Lr.No. D.Dis.A1/11950/89

Dated: 5.7.90.

Sub: MMDA - Planning Permission - Additional
Construction of residential building to
the existing building in Plot No.37 at
S.No.526 of Thiruvottiyur village -
Approval - Regarding.

Plan showing the Proposed additional Construction in the existing building at plot no. 37 in RS. no. 526 manickam nagar thiruvottiyur village thiruvottiyur municipal limit.

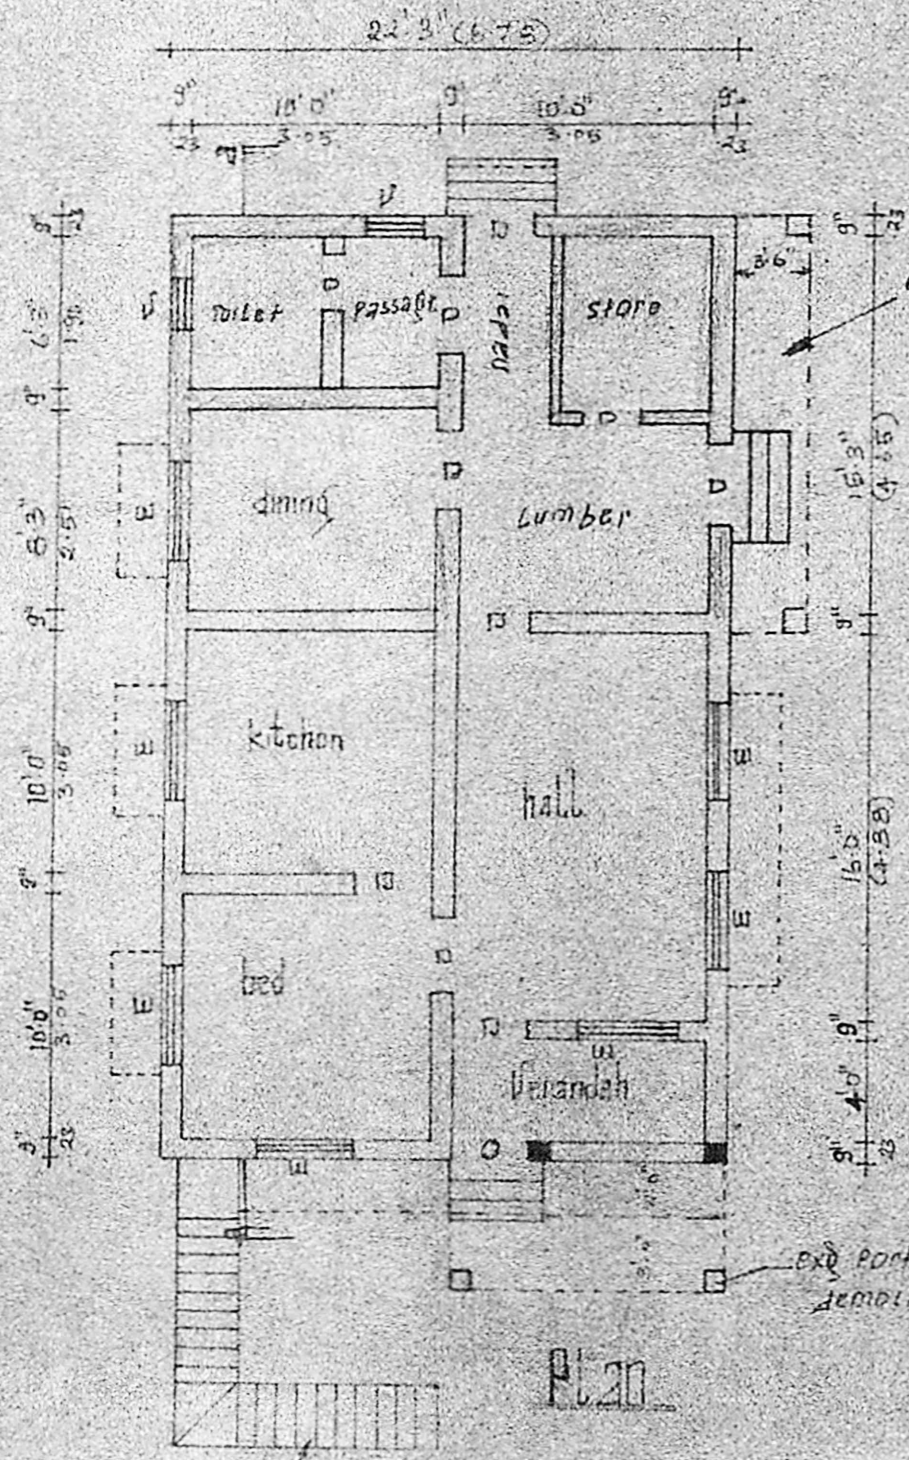
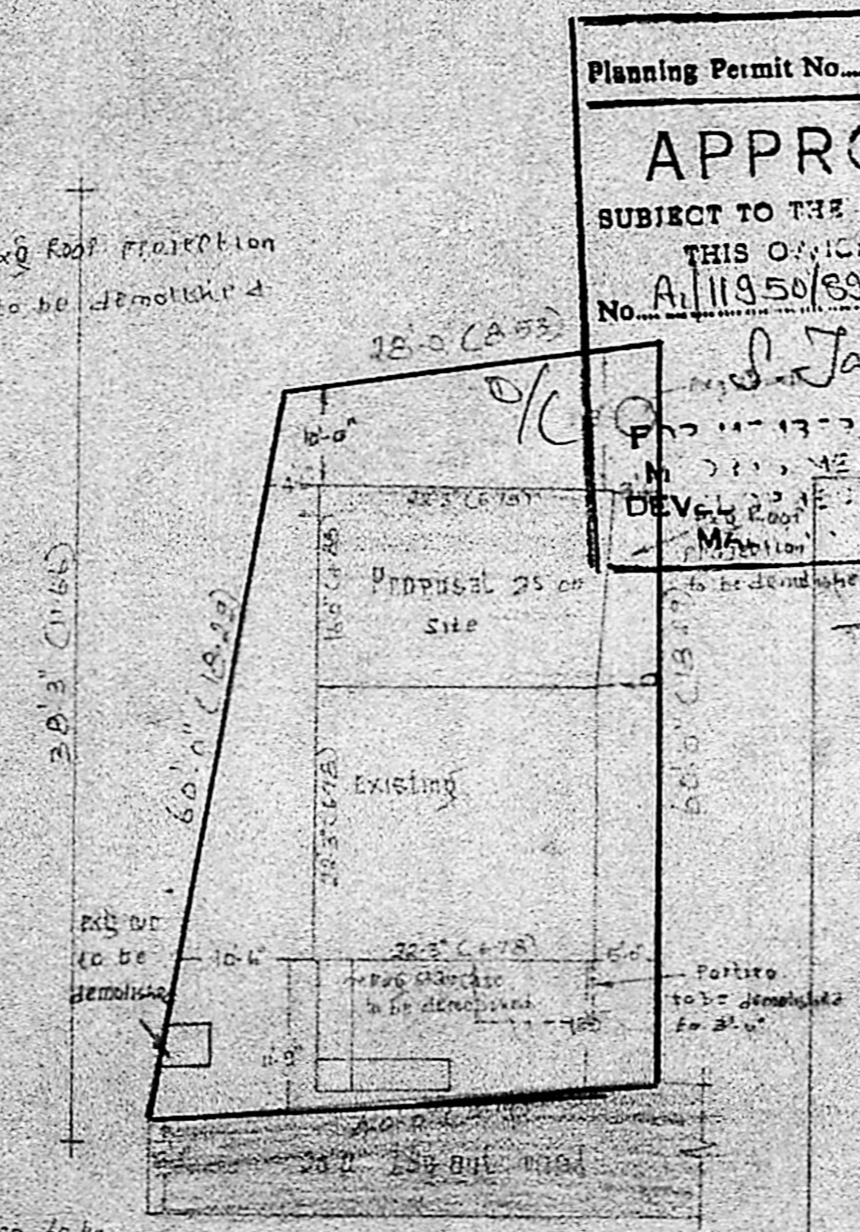
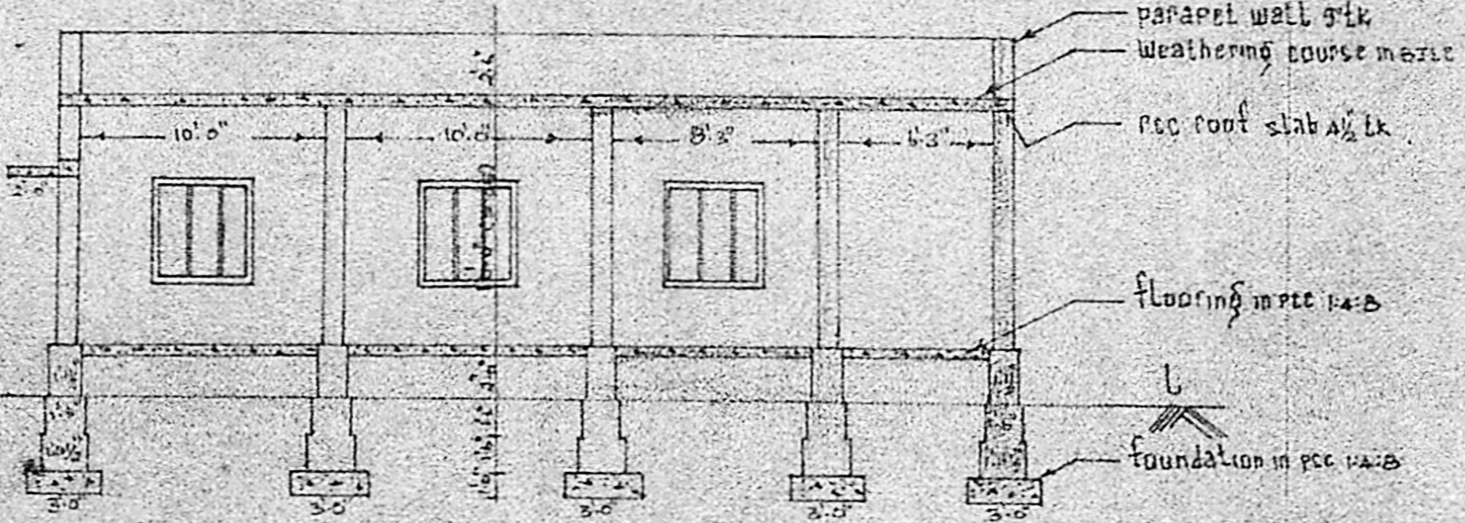
1. Issue Building Permit after demolishing the portion
proposed for demolition shown in the revised plan.
- i) 'in the open space within the site to the
extent feasible trees be planted and the
existing trees preserved'
- iii) 'it was requested to ensure that the plans
for the new buildings will incorporate the
approved designs for mosquito-proof overhead
tanks and wells.
- iv) 'improvement charge, Open Space Reservation
charge and other charges as applicable.
